Appeal Decision

Appeal Ref: APP/R5510/W/24/3342929

18 Mead Road, Hillingdon, Uxbridge UB8 1AU

- The appeal is made under section 78 of the Town and Country Planning Act 1990 (as amended) against a refusal to grant planning permission.
- The appeal is made by Mrs Mandy Barnes against the decision of the Council of the London Borough of Hillingdon.
- The application Ref is 68180/APP/2023/3376.
- The development proposed is described as 'Division of site to construct new 2 bedroom dwelling'.

PROPOSED
Drawing Number:
2381-PL-103
Scales:
1:50 @ A3
Rev. No.
—

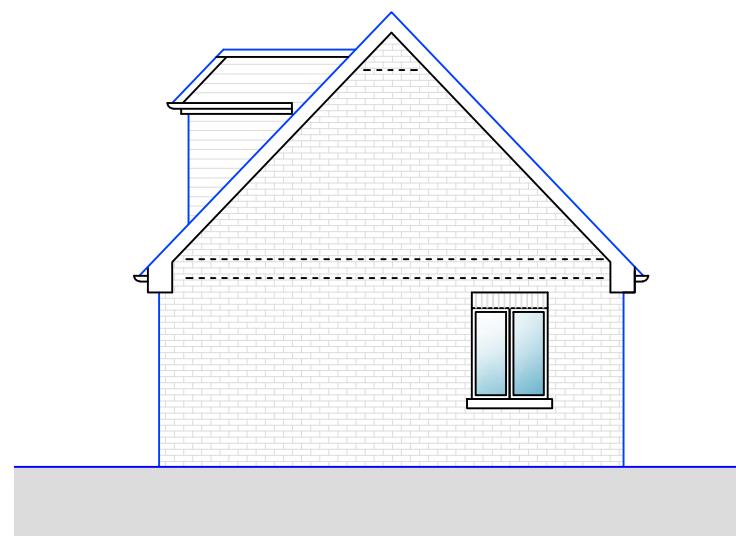
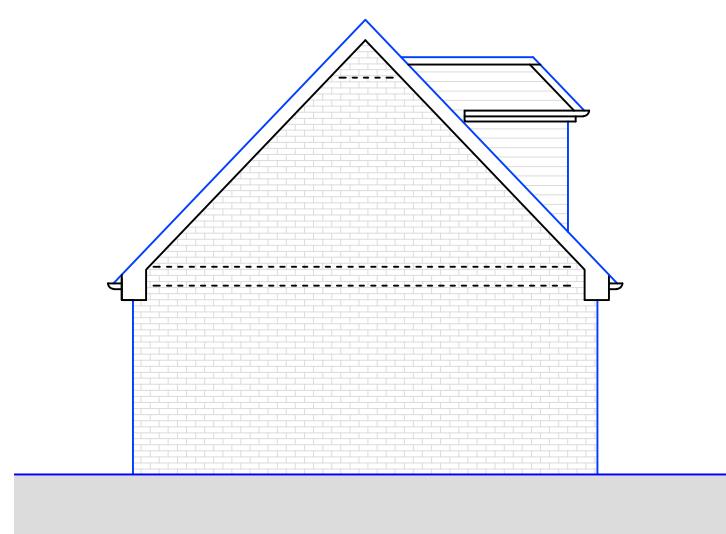
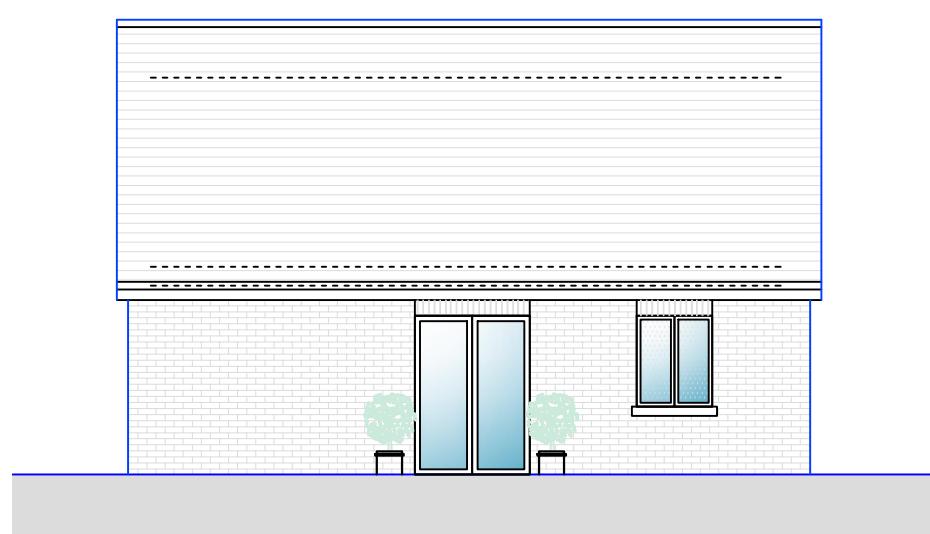
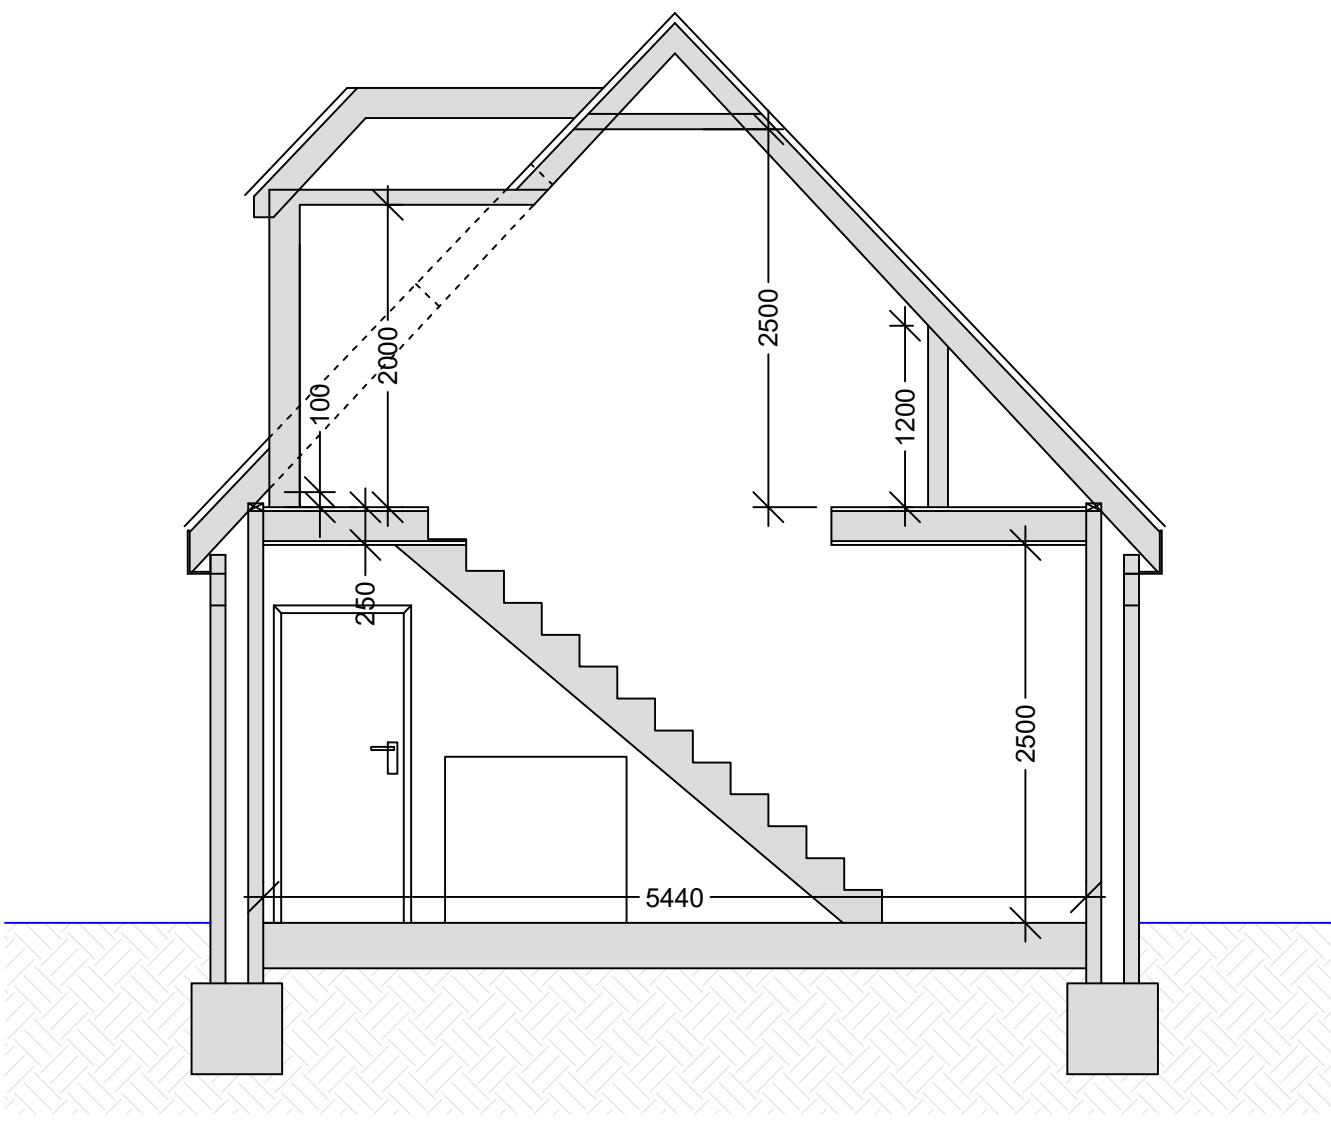
8. Furthermore, the 1.5 storey height and insertion of a hipped roof dormer within the front roof slope of the proposed dwelling would appear conspicuous in comparison to the larger scale and massing of the 2 storey dwellings on the opposite side of this part of Press Road, and the smaller size, scale and relatively simple form of 13 Fairfield Road's nearby existing outbuilding. Indeed, the impact would be compounded by the proximity of this outbuilding to the front and side elevation of the proposed dwelling, thereby drawing the eye, and further accentuating its discordant effect.
